ANNEX D

**DESIGNER'S RESPONSE TO ROAD SAFETY
AUDIT**

This report provides a designers response to the results from a stage 1 road safety audit (RSA) carried out on the M4 Smart Motorway All Lane Running (MM-ALR) Junction 3 – Junction 12 scheme at the request of the Project Sponsor, Lynne Stinson (Highways Agency, Birmingham).

The RSA stage 1 report (Report Ref: 514451-MUH-00-ZZ-RP-HW-300354 dated 7th January 2015) was received by the design team and the recommendations made in the RSA report have been reviewed accordingly. The recommendations and exceptions have also been discussed at the Project Safety Review Control Review Group (PSCRG) held on 5th February.

EA Reference E9-A2

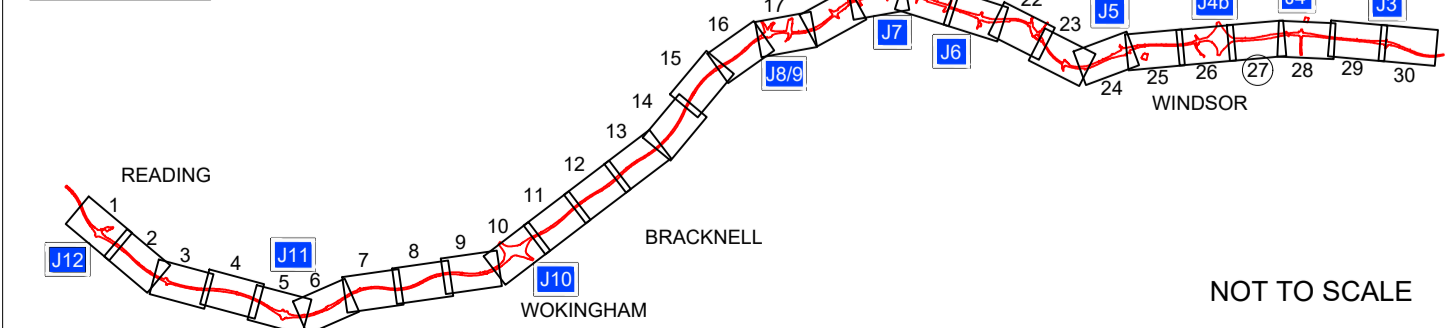
There is an existing MSA signs located in the vicinity of the proposed ERA facilities. There is a risk that the signs will create a barrier to visibility in the vicinity of the ERA leading to potential collisions. Additionally, the signs may create driver confusion if they are located before the ERA with the risk of drivers inadvertently mistaking the ERAs for the exit points for the MSA.

Ensure the signs do not impede visibility or cause driver confusion.

The design team agree with the recommendation. The assessment of verge signs and their impact on visibility along with their relocation will be dealt with during the detailed design stage.

Junction 11 Eastbound Off-Slip  
Chainage 55250.000 Work No. 4a  
Works Plan Sheet 5

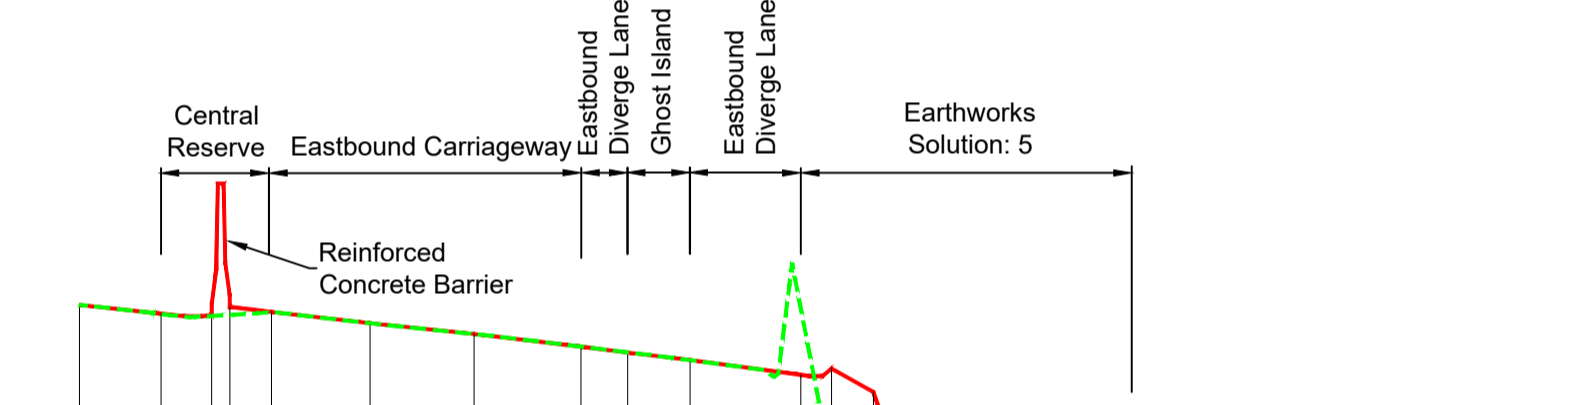
The drawings provided appear to indicate that the existing hardshoulders located on both the eastbound and westbound diverge slip roads will be removed as part of the proposed scheme. However, the spacing of the mainline ERAs appears to have used the junction diverge slip roads as ERA. IAN 161/13 states that an exit slip with a hardshoulder can be used as a refuge area. If the hardshoulders on the slip roads are removed it could result in spacing between ERAs becoming excessive. This would increase the risk of vehicles stopping in live running lanes leading to shunt type collisions.

Ensure that spacing between ERAs complies with IAN 161/13 by either providing hardshoulders on the diverge slip roads or increasing the number of ERAs on the mainline.

The design team agree with the recommendation. The spacing between areas of refuge will meet the spacing requirements of IAN 161/13.

The location/provision of an ERA, or safe area, on a slip road is currently included within IAN 161/13. The subject of provision of an ERA or a hard shoulder on the slip road at J11 was discussed at the Project Safety Control Review Group (PSCRG). Originally a grasscrete area was proposed as the preferred option. PSCRG concluded (this included NetServ, TMD and NDD) that the preference was for no provision, as the use of a dedicated area would most likely be misused.
